1 December 2021

Our Reference: SYD16/00625/17  
DPIE Reference: SSD-9978934

**SSD-9978934: EXHIBITION OF ENVIRONMENTAL IMPACT STATEMENT (EIS)  
STAGE 2 COCKLE BAY WHARF MIXED USE DEVELOPMENT  
249 WHEAT ROAD, COCKLE BAY**

B	ISSUE B	NT 29/09/21	
A	ISSUE	NT 08/09/21	
REV	DESCRIPTION: PRELIMINARY PLAN	DRAWN	INITIAL/DATE

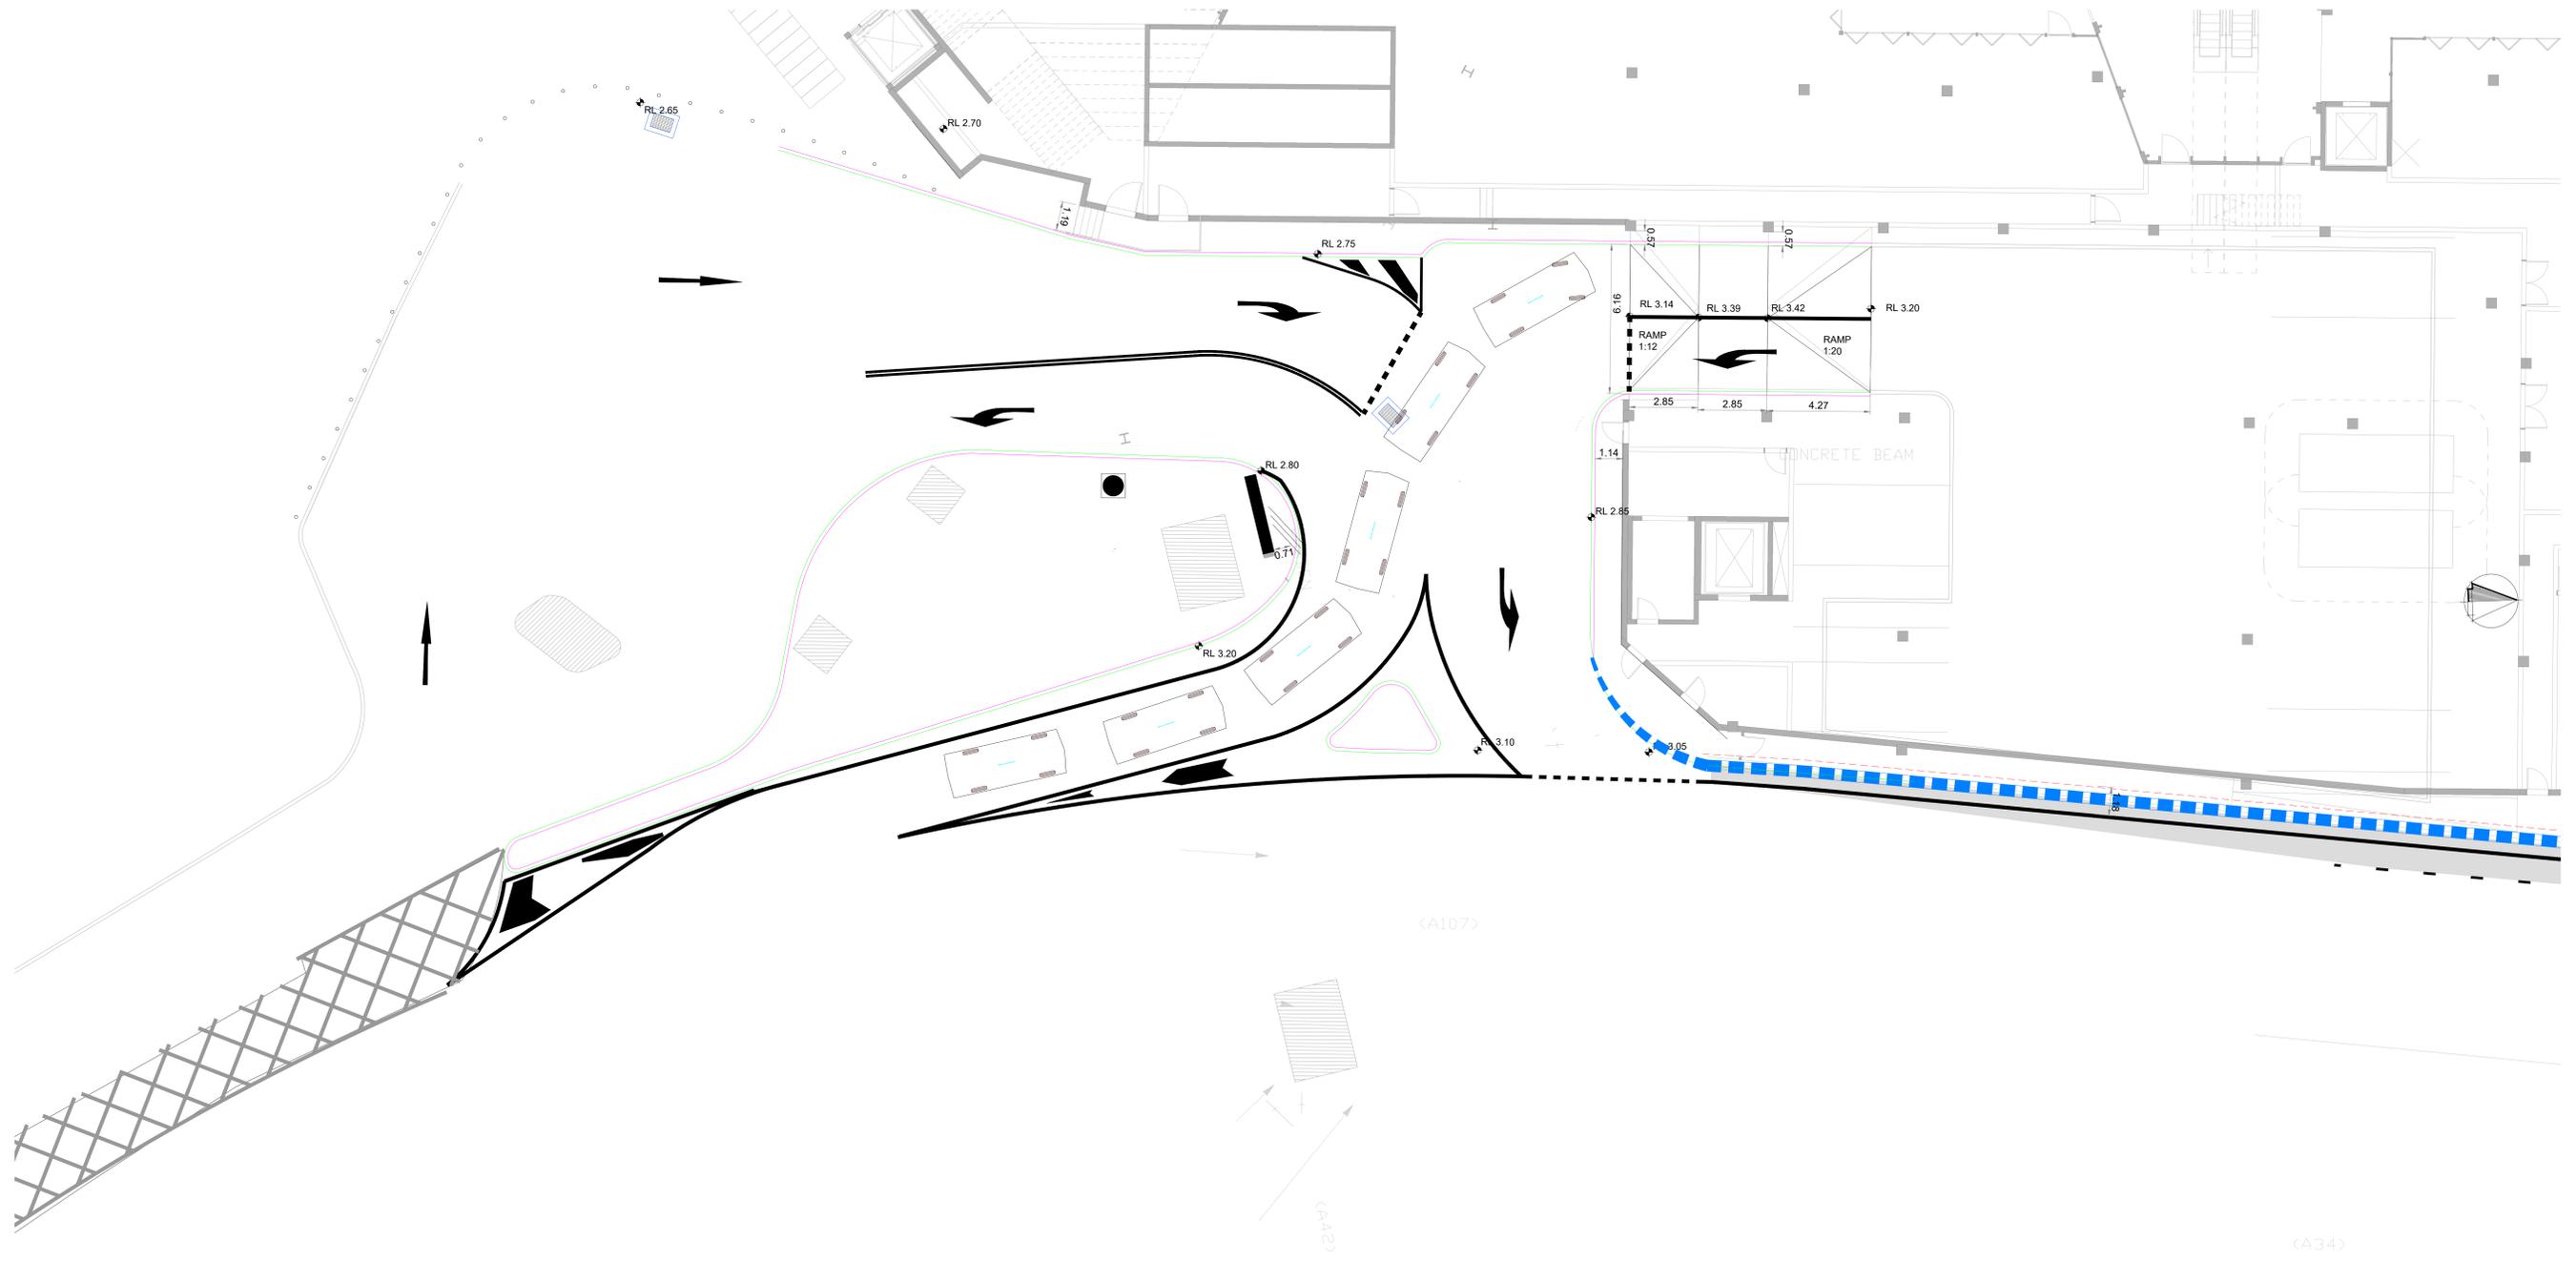
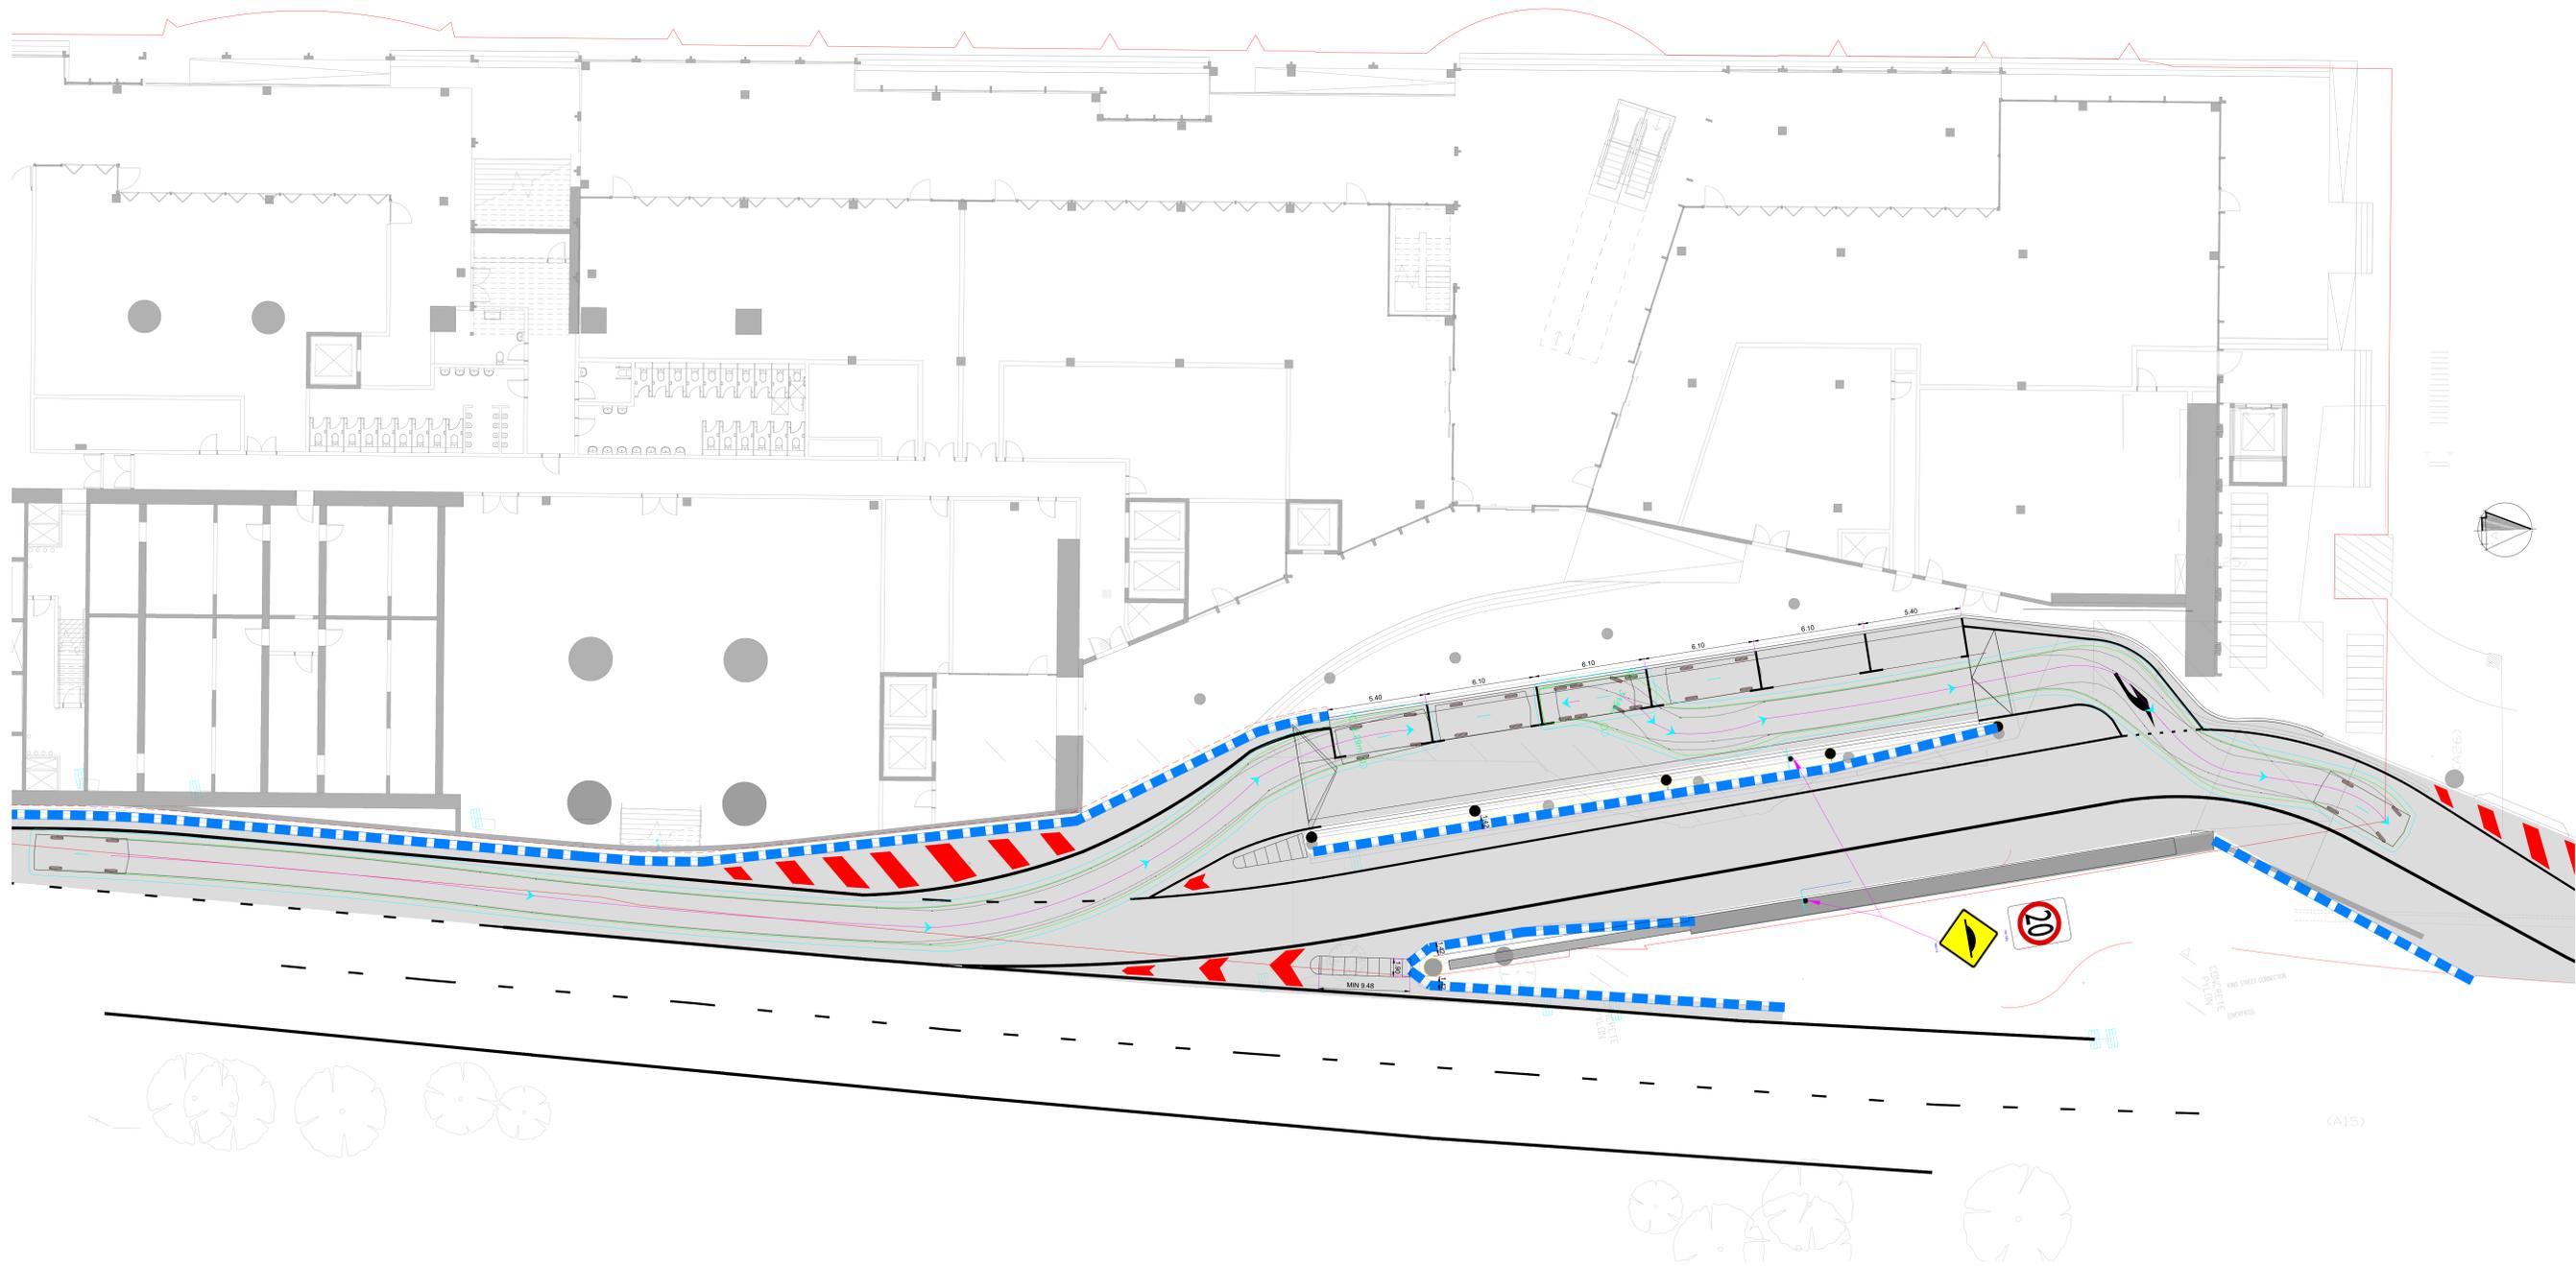
- Further it is not clear if the vehicle drop off, including ingress and egress, has been designed to accommodate stretched limousines which may serve the proposed development and the maximum coach size that the proposed Wheat Road configuration has been designed to as this is not clear from the swept path analysis provided in the Traffic Impact Assessment. It is also noted that the swept path analysis identifies that the coach design vehicle encroaches into the land outside of the proposed extent of the Wheat Road roadway.

- Details of the largest vehicle size that the proposed vehicle drop off, including ingress and egress and Wheat Road configuration have been designed should be provided (including swept paths and vehicle clearance heights), taking into consideration the use of coaches and stretched limousines within the vehicle drop off and Wheat Road configuration. Further, provision of a swept path analysis identifying that the proposed Wheat Road configuration adequately accommodates the coach design vehicle should also be provided.
